CITY OF ALBUQUERQUE

January 22, 2014

**Re: Presbyterian Systems Office
9521 San Mateo Blvd. NE
Request For C.O. PERM
Engineer's Stamp Date 11-23-13 (B17/D003)
Certification Stamp Date 01/20/2014**

SHEET NO.
C-103
OF

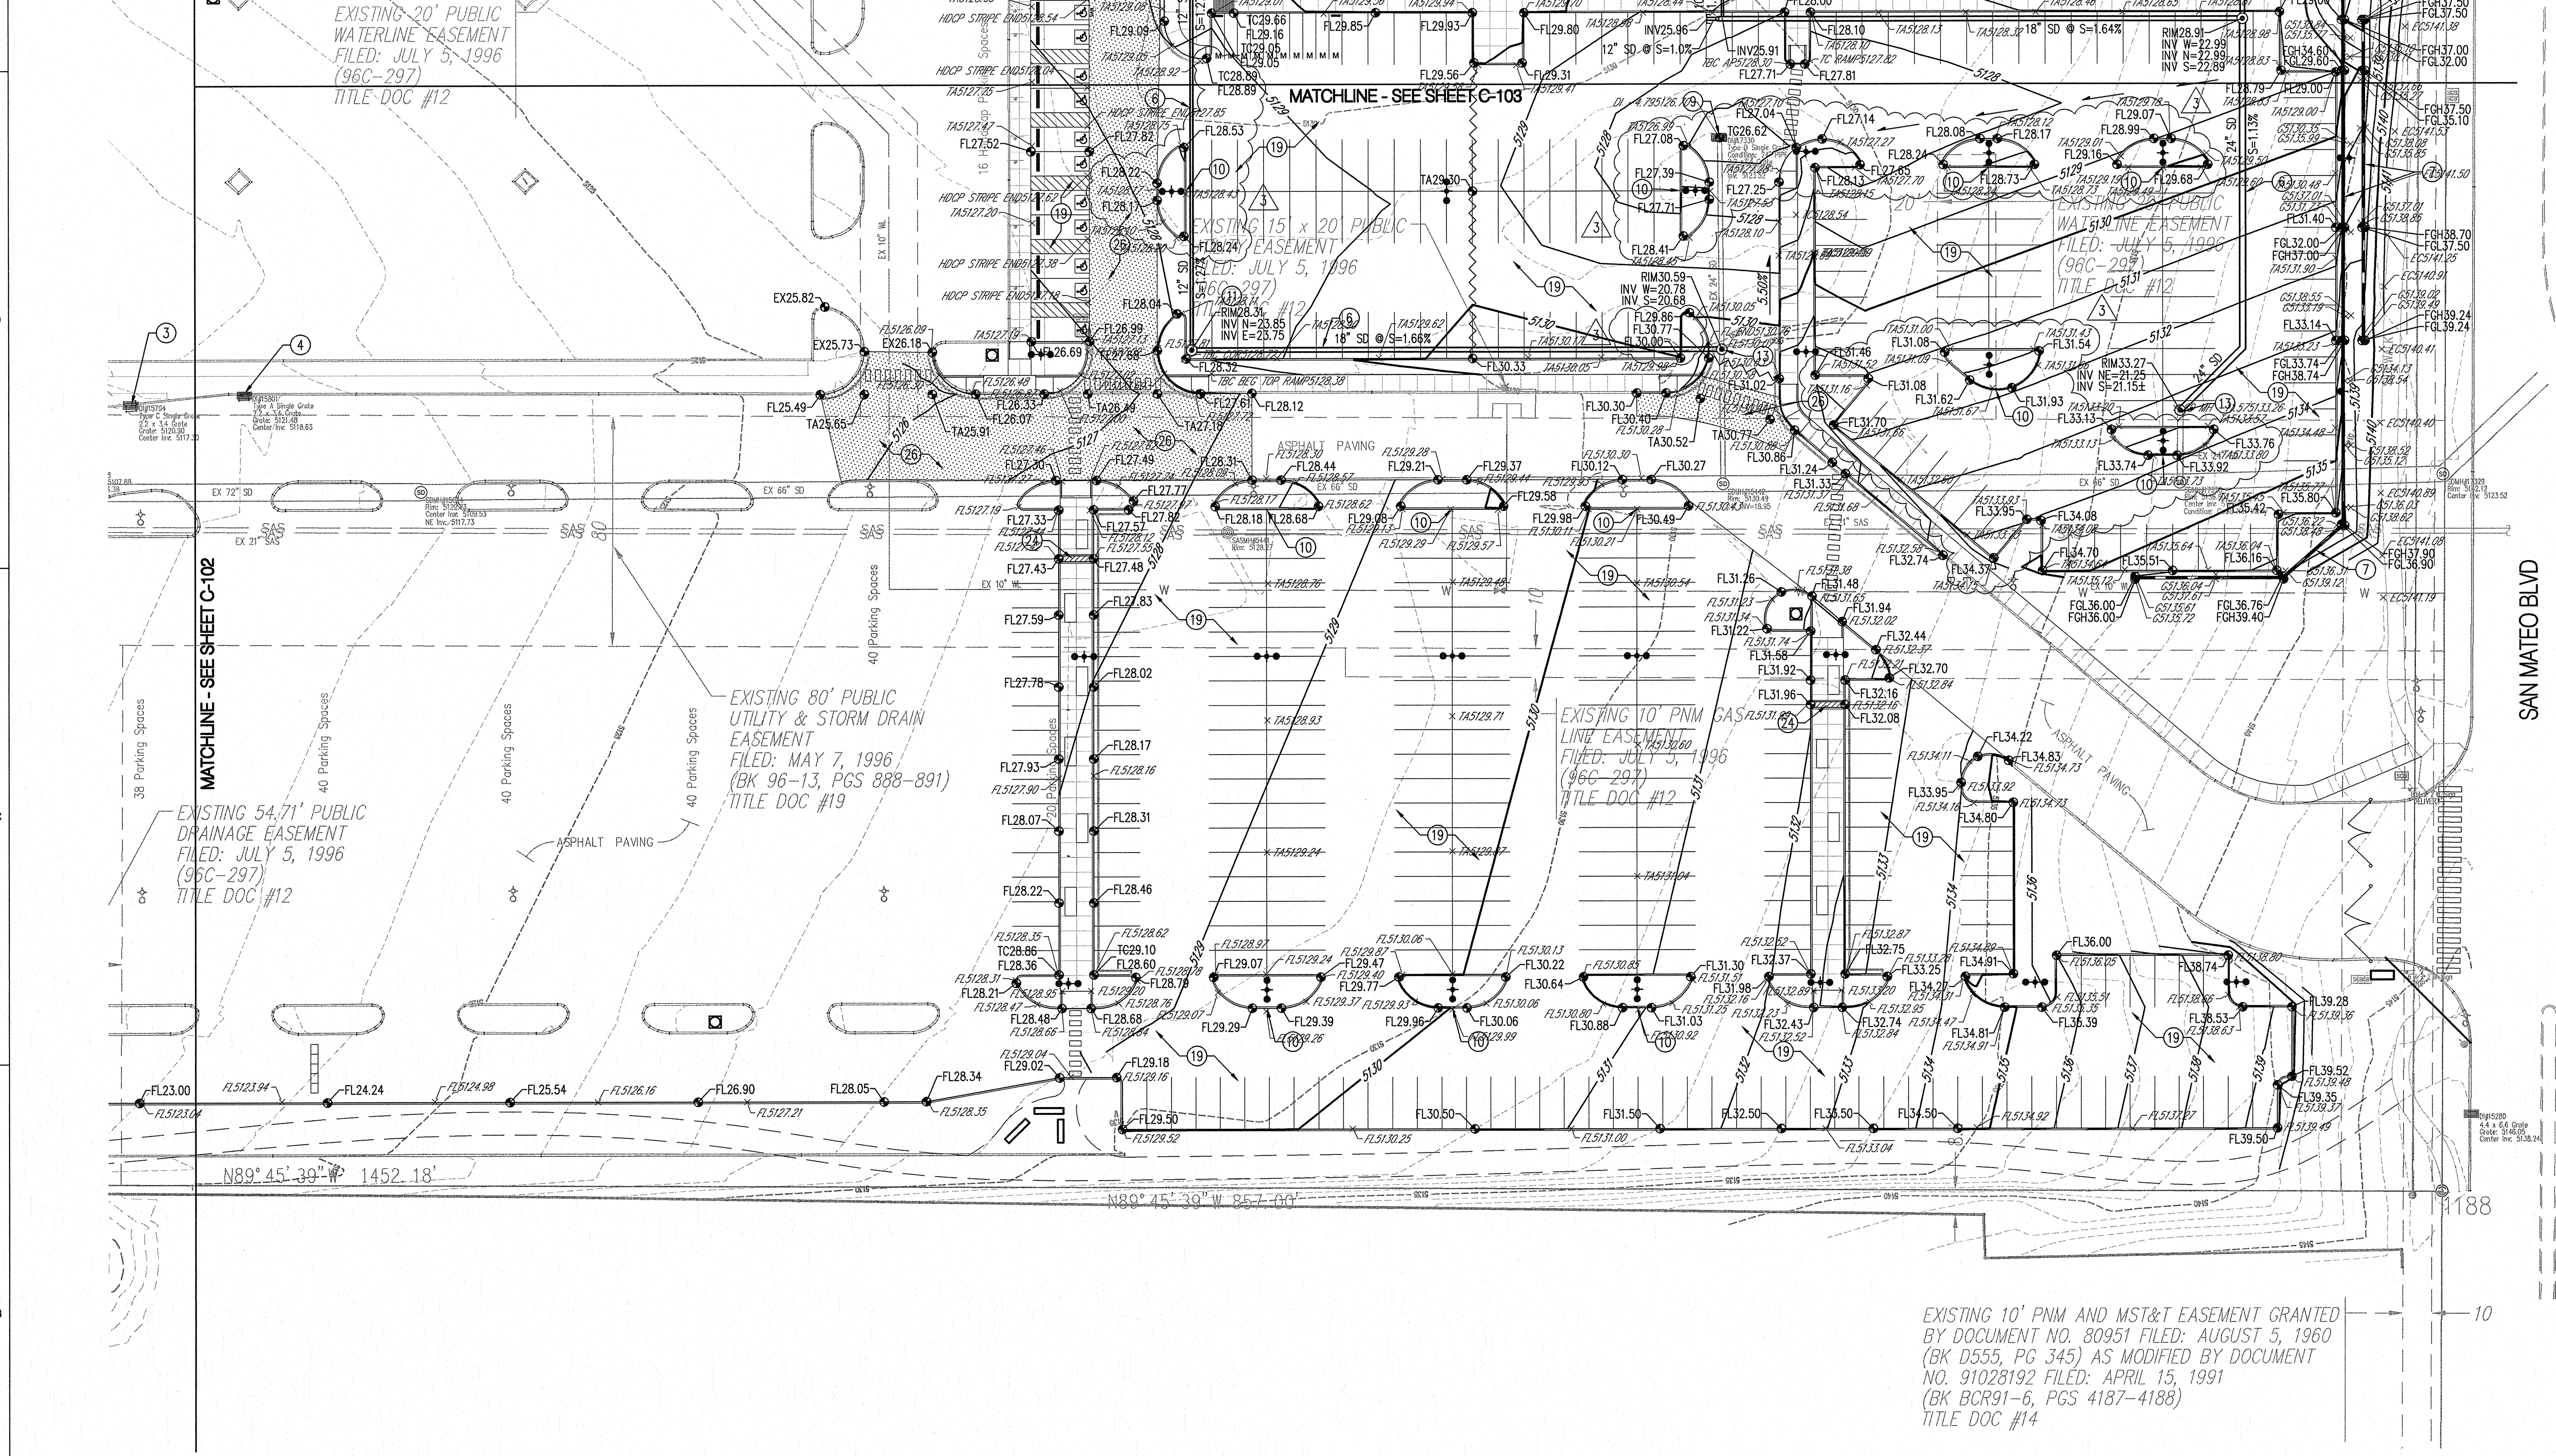
During an on-site inspection there is a concern with the slopes along the fence line on the South side of the property. Please provide a plan mitigating the slope along the fence on the South side of the property.
